7 September 2020

As discussed at our last meeting regarding the proposed signage to be placed on the corner of Marian and Cornwallis Streets I have circulated your most recent mock ups to those in The Watertower who have expressed interest in commenting. Obviously, this is not all residents as the sign will only affect those living along the West wall facing into the South Eveleigh precinct.

FRONT VIEW - NIGHT
SCALE 1:75

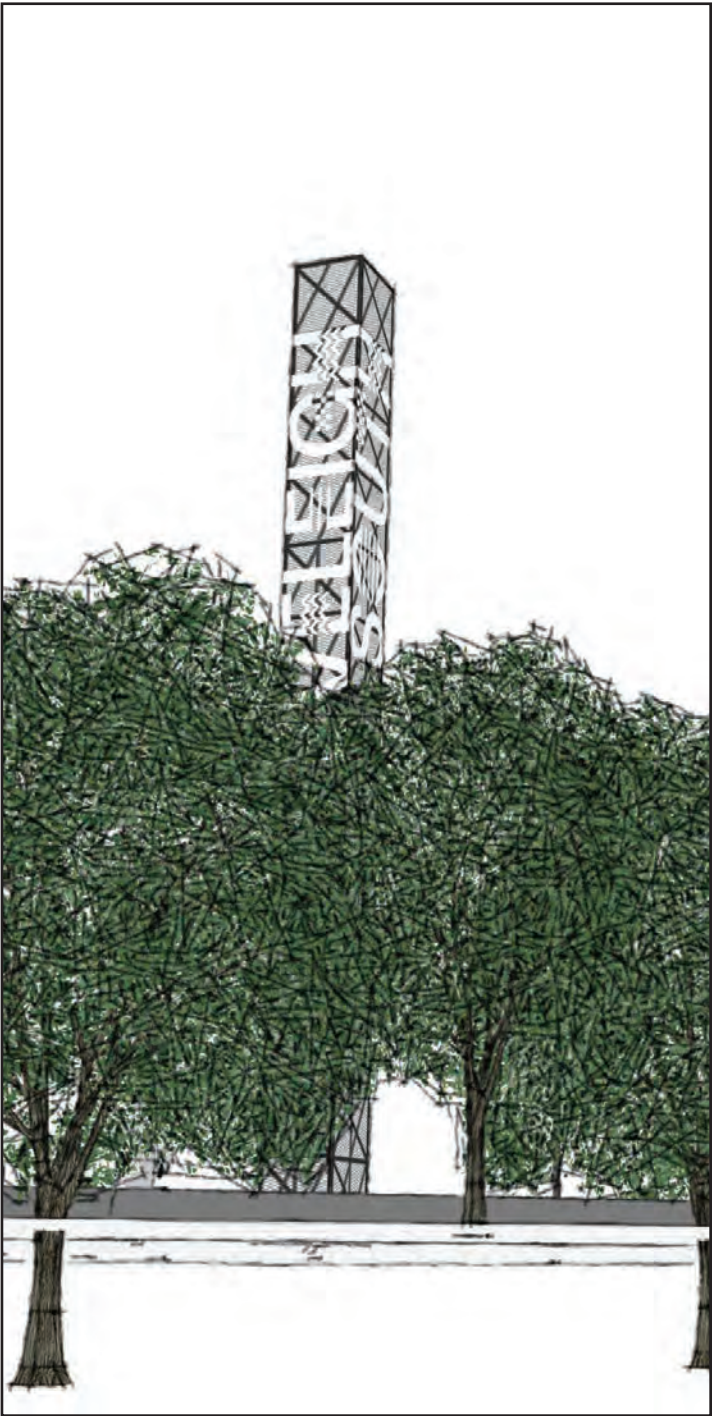
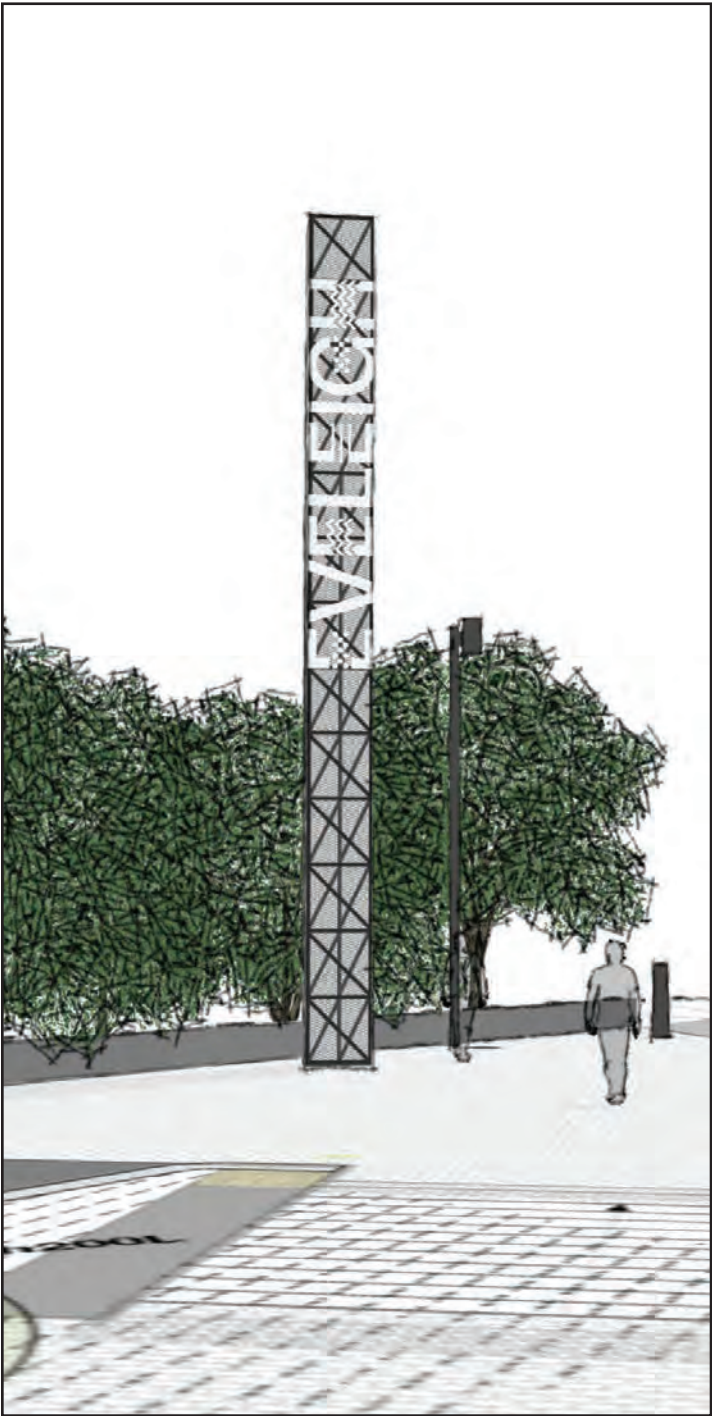
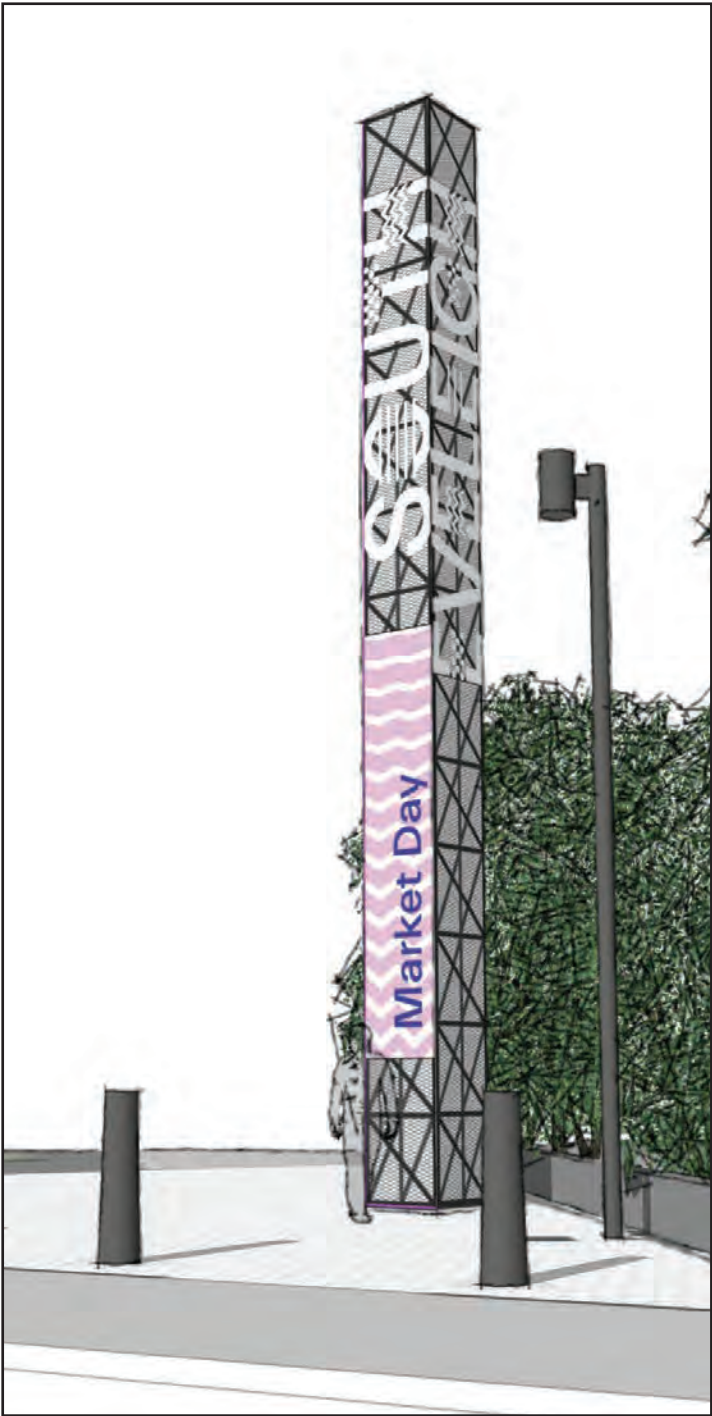
The overwhelming preference is for Option 1 which does not include a digital display. Some were also happy with other options.

- The main proposed sign is tasteful and compatible with the overall ambience and Zeitgeist of the entire site, especially its numerous references to Aboriginal heritage and culture. That said, the proposed tasteless red and blue monstrosity detracts to a similar extent in the opposite direction. I support the main proposed sign and urge

Mirvac to abandon the "add on" blue and red one, at the very least, at the entrance to the precinct.

Most people I have spoken with have expressed real concern about the hours the sign will be illuminated. We note that the lighting in option 1 as proposed will be downwards and are appreciative on the sensitivity this shows. We also note that the precinct will have some workers on 24/7 shifts and some retail will be open until 2.00am if all DA's are approved in their current form. However, we contend it is unlikely that people who are unfamiliar with the precinct will be arriving after 11.00pm and we strongly urge that the lighting in the sign be switched off at that time.
